From: [HPOA HYAK](#)
To: [Zach Torrance-Smith](#); [HPOA HYAK](#)
Subject: Pazaruski Reasonable Use (RU-26-00001)
Date: Friday, April 24, 2026 1:39:04 PM

We are writing to comment on the Notice of Application for the Pazaruski Reasonable Use (RU-26-00001) project with parcel number 558535.

LOT 9 HYAK ESTATES 2 GRADING DESIGN
RYAN PAZARUSKI
SITE PLAN

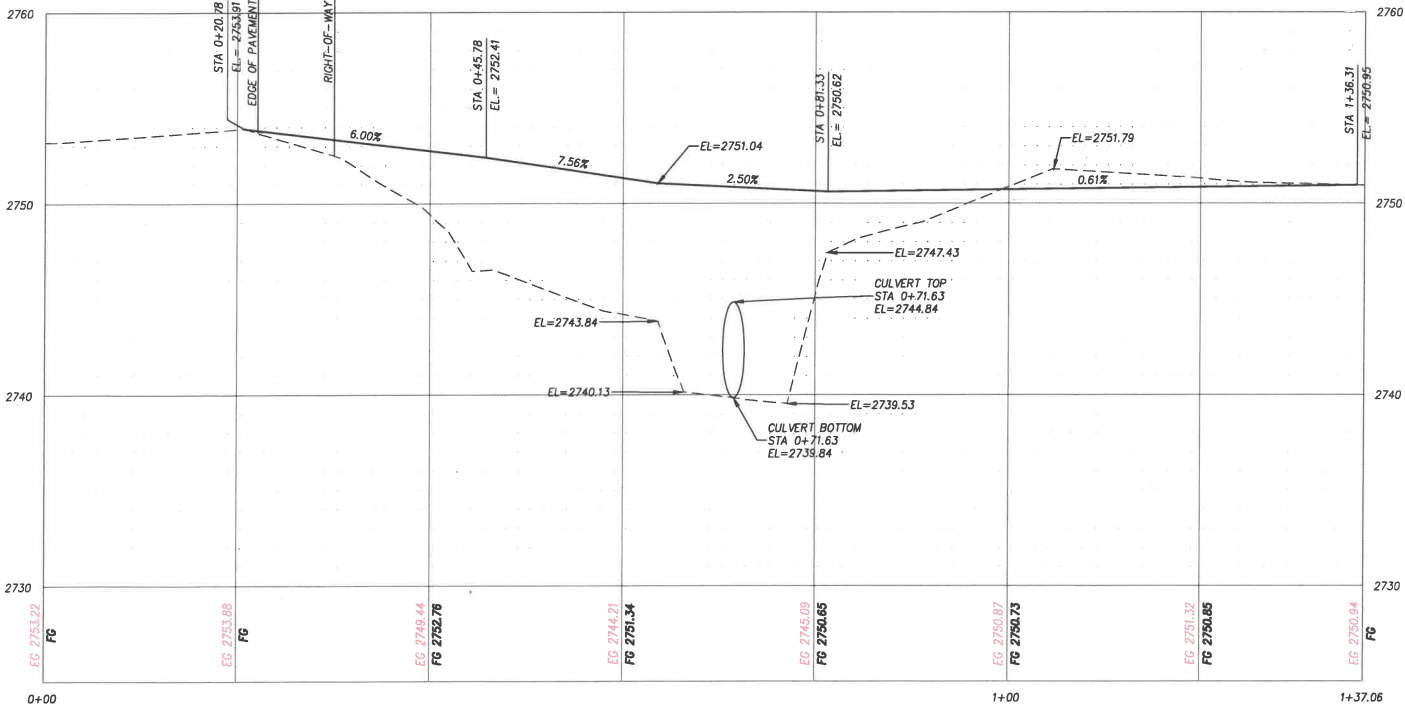
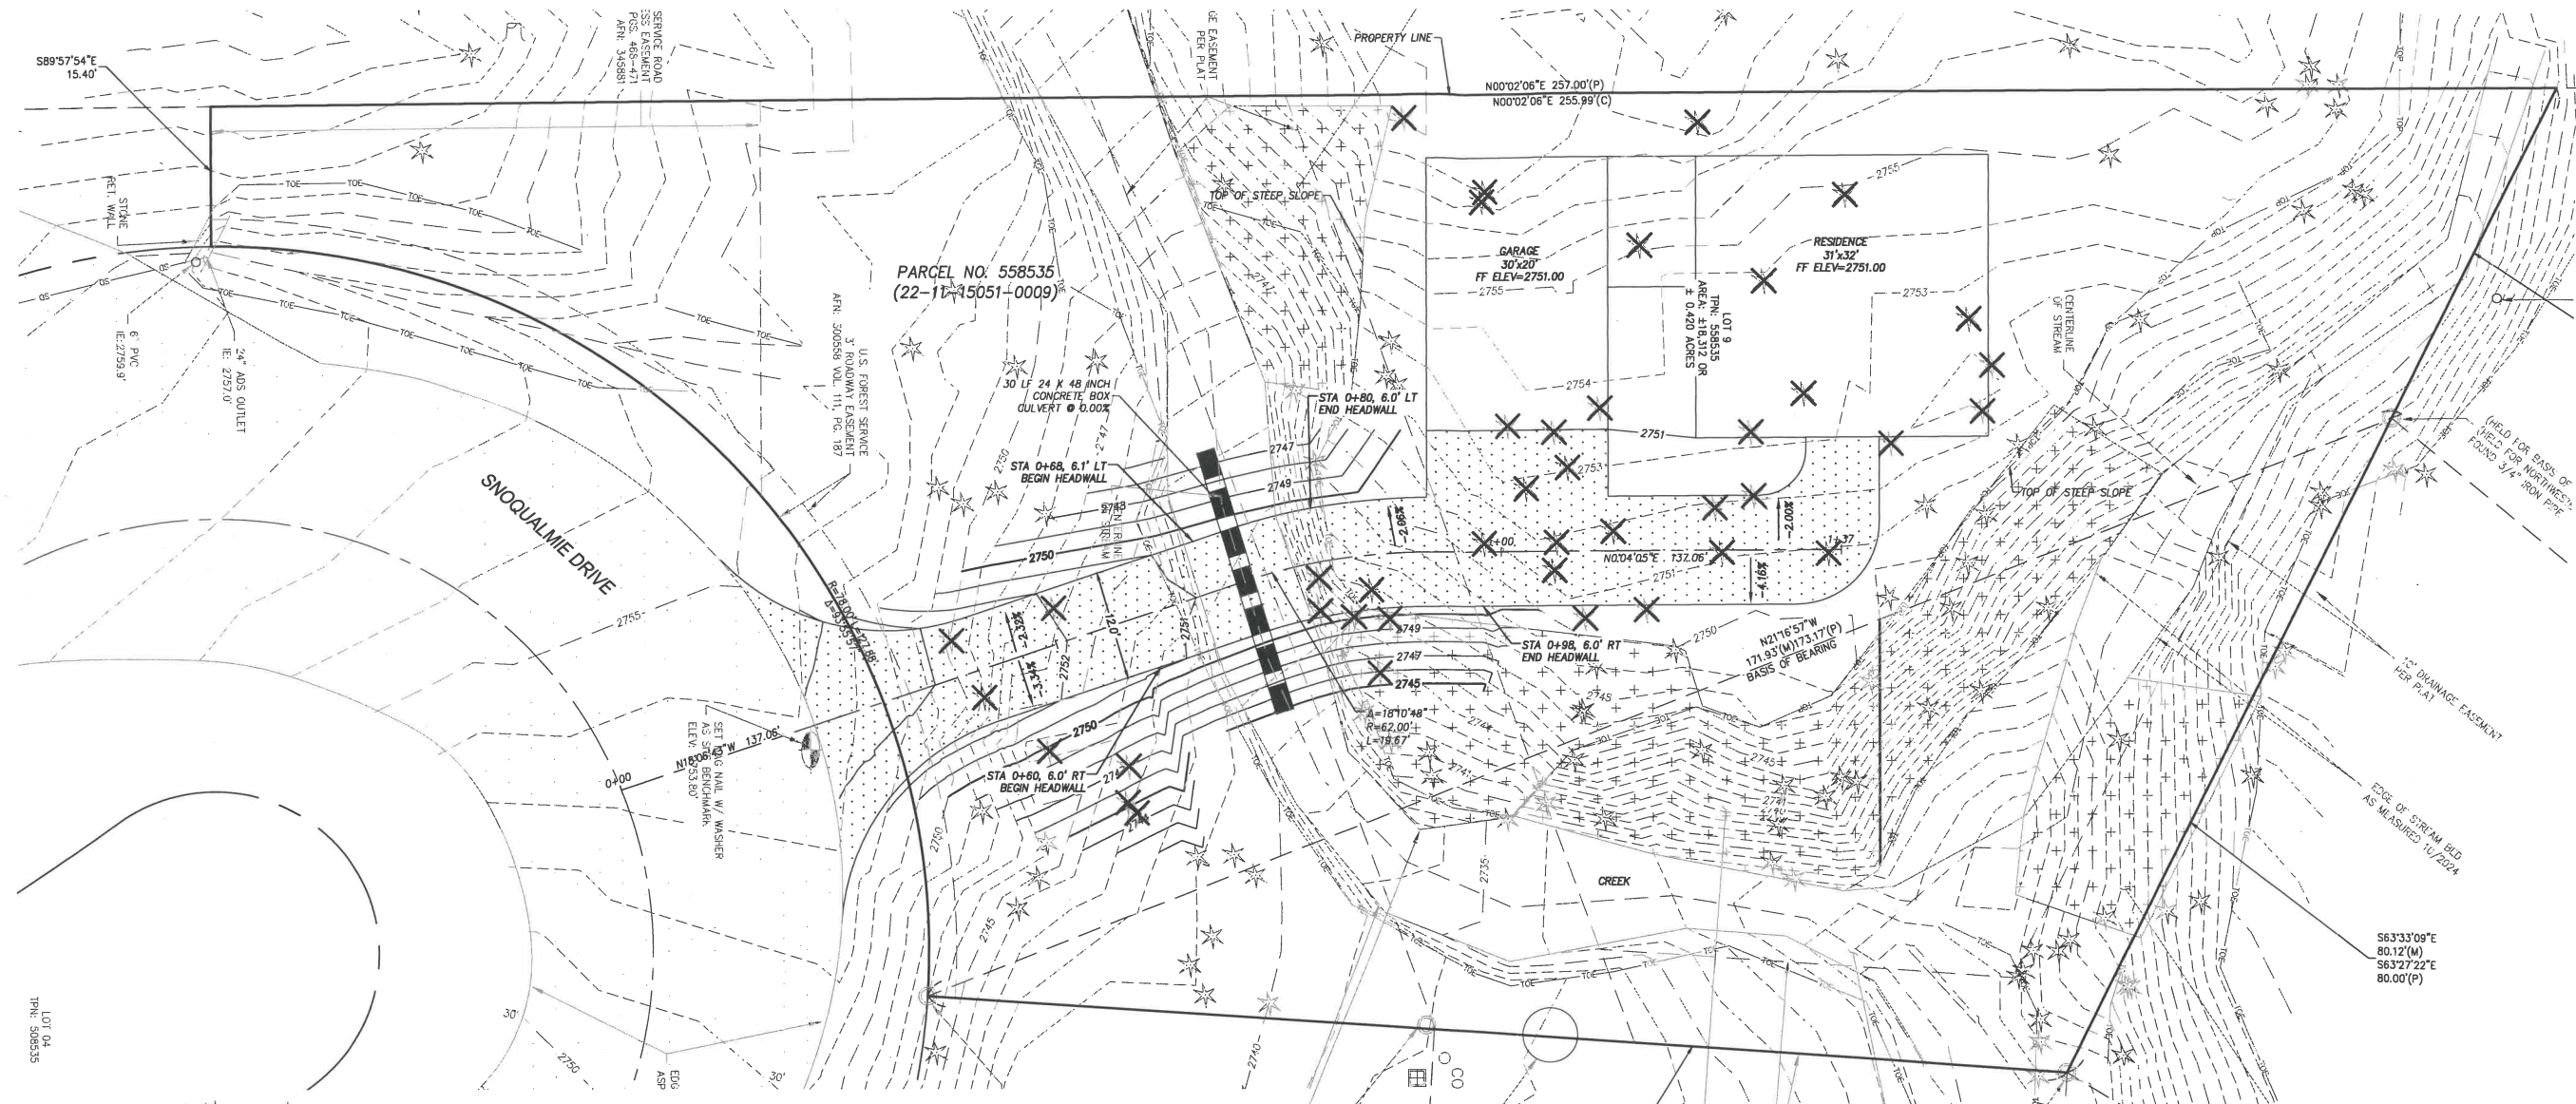
- The plans the HPOA received have a garage footprint of 31' by 32'. Site plans submitted to us and the county show a site plan with a garage of 20' by 30'. We were told changes were still being made but we have to go off information provided. These differences must be addressed prior to any approval.

- We asked specifically about the size of the culvert that will be using for the driveway over the first creek. In the owner statement to Kittitas County, statement mentioned that it'll be "installed in accordance with applicable engineering and environmental standards to ensure proper drainage and maintain stream function". In our March meeting, property owner verbally mentioned the next culvert down is 3' so theirs will likely match that. During this past winter, we had significant rain and surface water drainage that caused damage to homes and the entrance to the Hyak neighborhood. The HPOA board will not be held liable for damages that may result from culvert placement if not the correct size or placement or if water drainage changes due to improvements on this property. We ask that Kittitas County fully review plans for any and all alterations made to this
